The Sizewell C Project, Ref. EN010012

Issue Specific Hearing 7 (15 & 16 July 2021) – (ISH7) Biodiversity and Ecology

Post Hearing Submissions including written summary of Suffolk County Council's Oral Case

Suffolk County Council Registration ID Number: 20026012

DRAWING TITLE:
MAIN DEVELOPMENT SITE
SSSI CROSSING (SZC CONSTRUCTION)

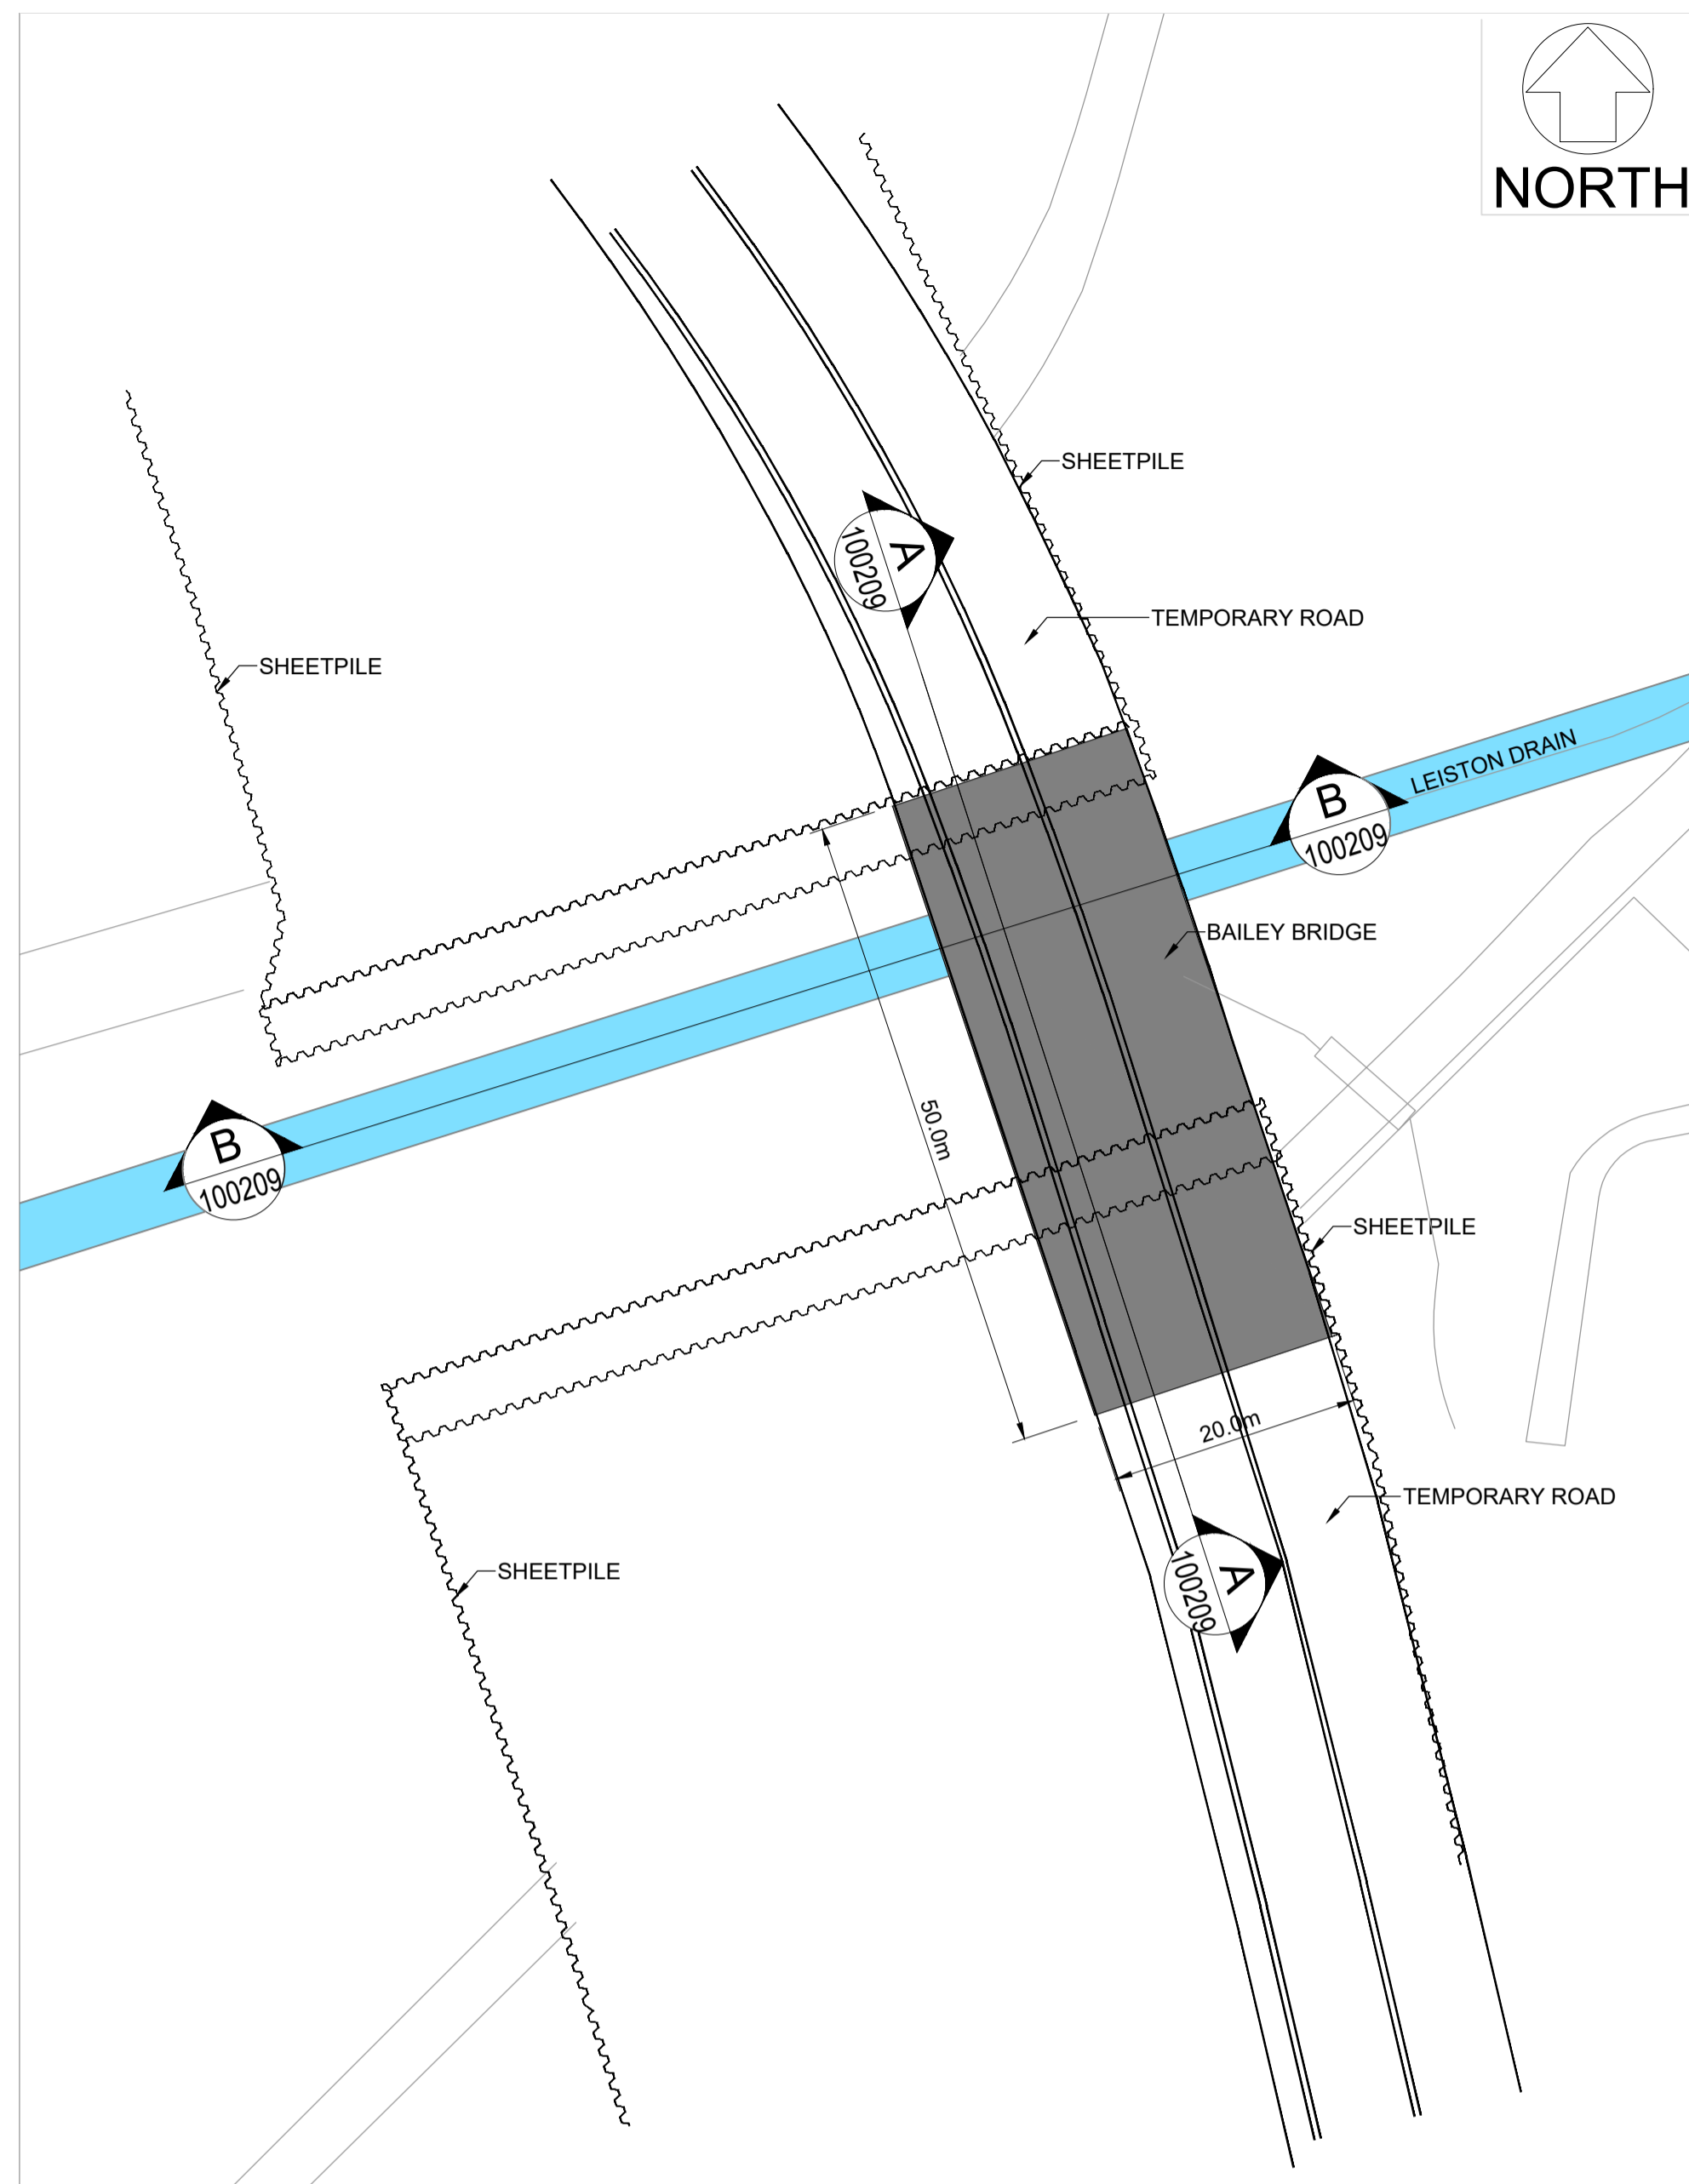
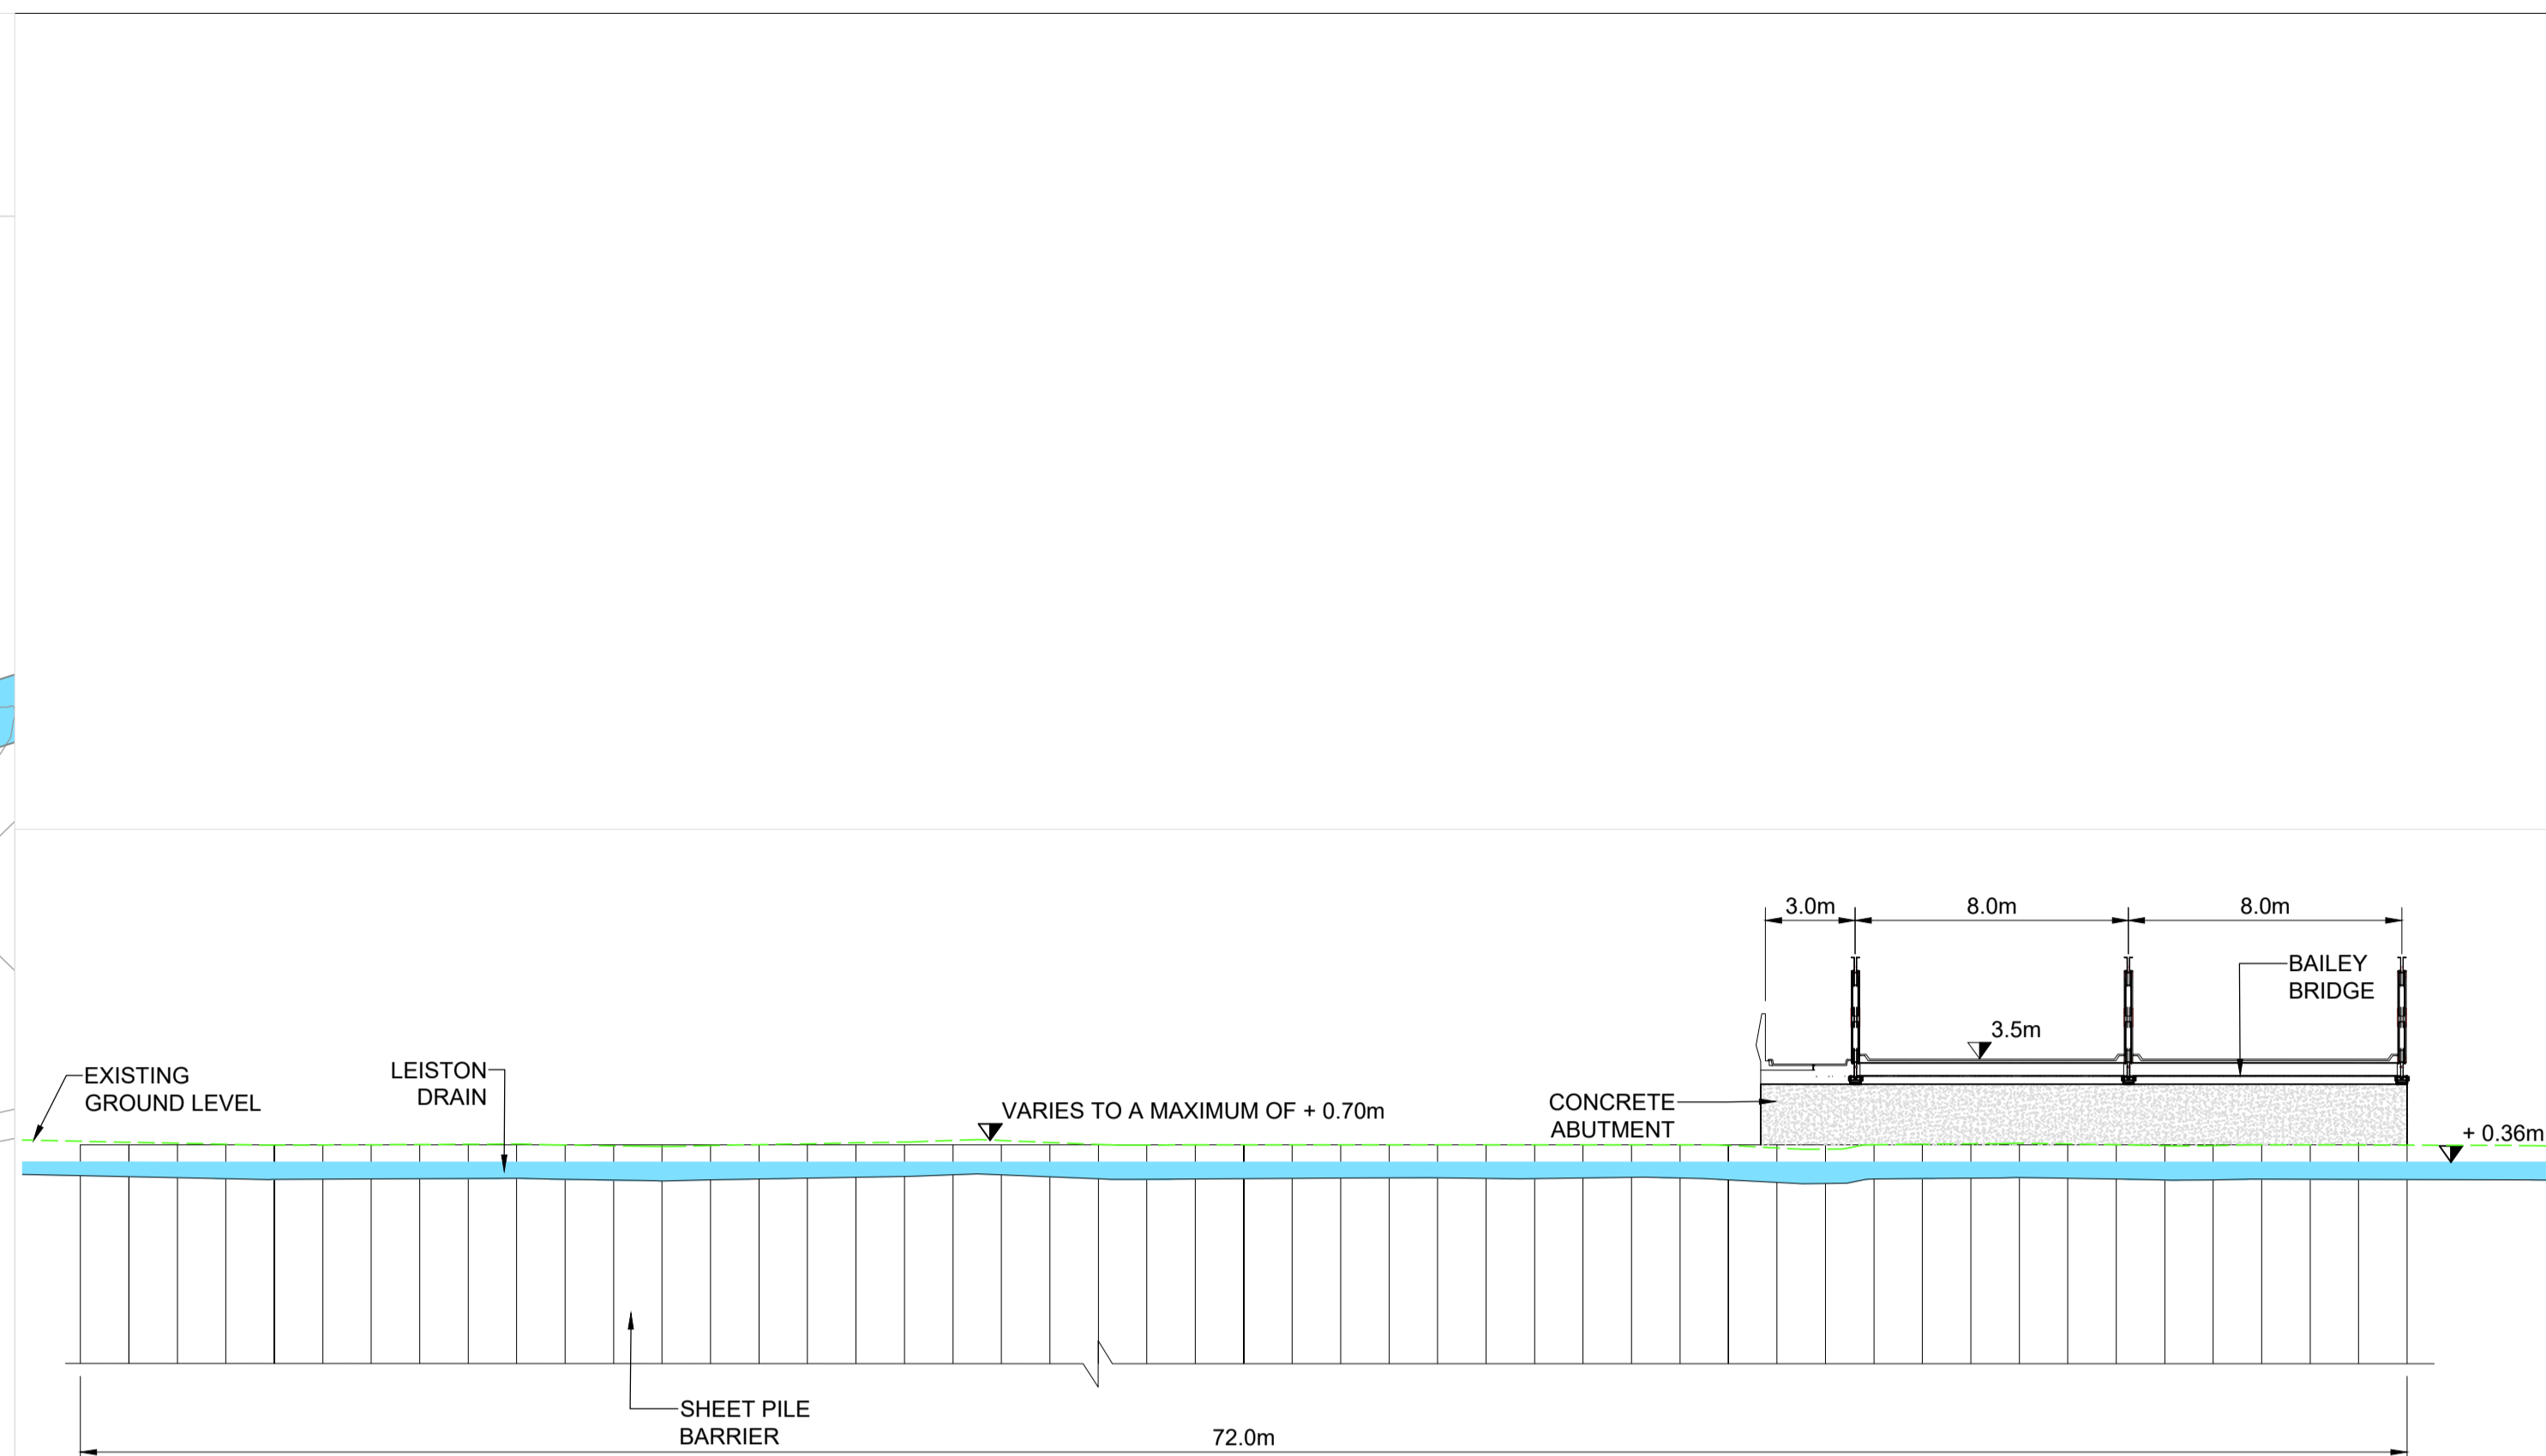
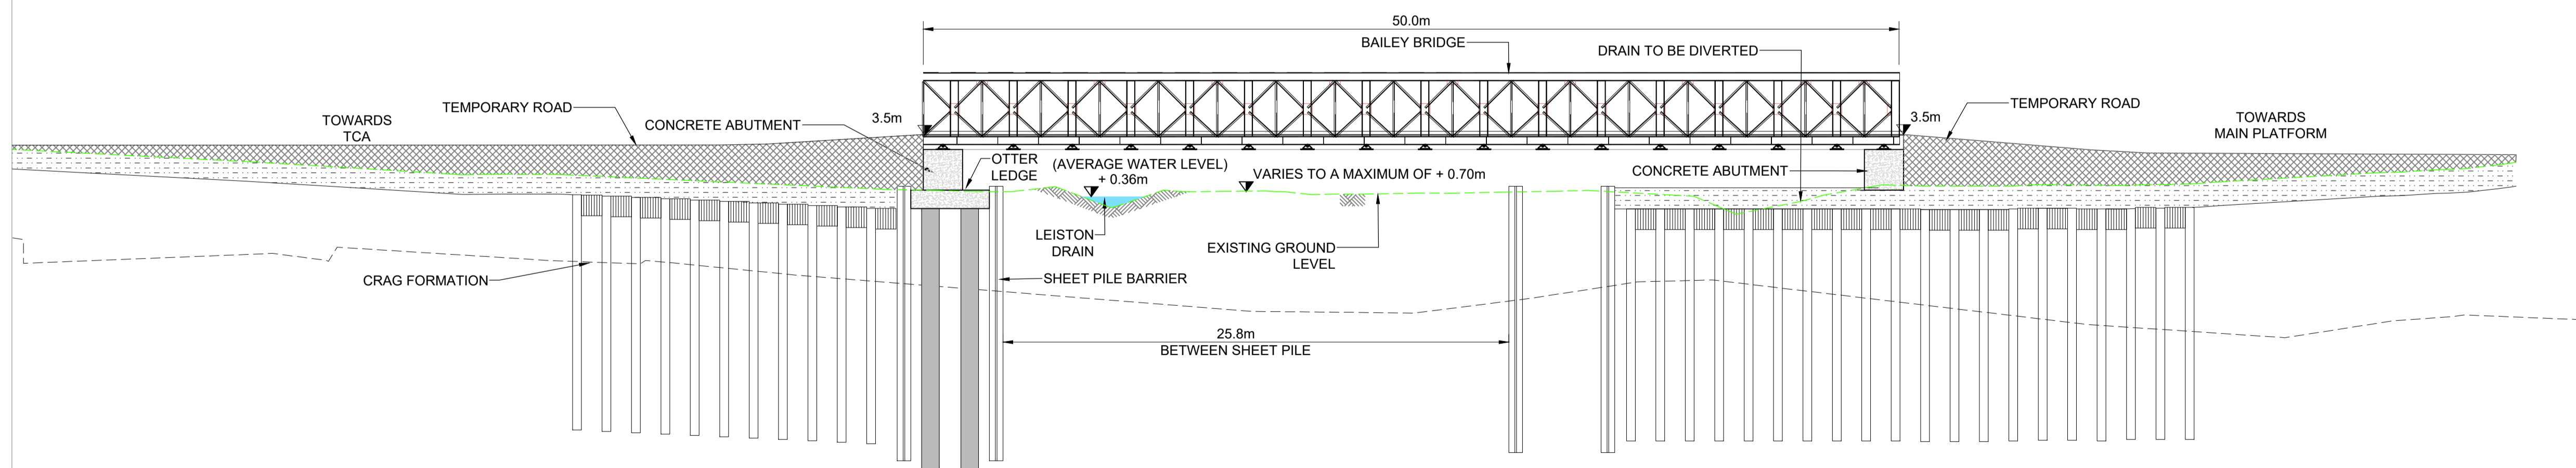
<p>whether the applicant could demonstrate this by providing a comparative plan which overlays the two proposals and shows the boundaries of the SSSI. We also asked for clarification as to whether the temporary construction land take utilised additional land within the SSSI and asked for this to be identified.</p> <p>We note that during the Stage 2 consultation process, as shown in [APP-072], the difference between the SSSI land take of the two options (i.e. option one and option three) in the construction phase is much larger at around one third of a hectare (see Tables 7.2 and 7.3 and Figures 7.21 to 7.24). Noting that option one has been superseded by the present causeway proposal, we would like the applicant to provide a similar comparison between option three and the present causeway.</p> <p>A fair comparison should also show the improvements to the present causeway design applied to the three-span bridge such as the removal of a 15-meter wide strip of the crossing deck.</p> <p>SCC notes from the Applicants response to ExQ Bio 1.47 the Applicant's intention to reduce the width of the bridge to approximately 15m once the power station has been built and their intention to submit updated indicative plans and further details at Deadline 5. SCC will review this once it has been provided by the Applicant to consider the extent to which it addresses the concerns that we raised on the proposed SSSI crossing design in our Local Impact Report at [REP1-045]. Whilst a reduction in the width of the permanent crossing is – on the face of it – a welcome positive step, we remain concerned about the impact of the much wider proposed temporary crossing on the SSSI and ecological connectivity whilst it is in place.</p>

<p>While the construction period is temporary, we are concerned that because it is so long that the relevant species and communities may have difficulty recovering in the long term. This could amount to a permanent deterioration of quality for the SSSI, even for a temporary direct impact.</p> <p>Requirement 12C Main Development Site: SSSI crossing Notwithstanding the debate about the nature of the SSSI crossing, SCC was concerned that, through Requirement 13 in the submitted dDCO, there was no means of controlling any element of the crossing save the height of the crossing (Zone 1E in Table 2.3 of Chapter 2 of the Environmental Statement Volume 2 (APP-180)). Therefore, SCC welcomes the greater clarification of the means by which the form of the crossing may be established in the revisions included in Revision 4 of the dDCO by the addition of Requirement 12C. Owing to the fact that the Applicant is due to provide updated plans, the Council anticipates that the exact wording may need to change to reflect the contents of those plans. On a detailed matter, though, R12C has been “carved out” from R13 but the terms of the text for R13 still purports to cover Work 1A(I), the SSSI crossing.</p>
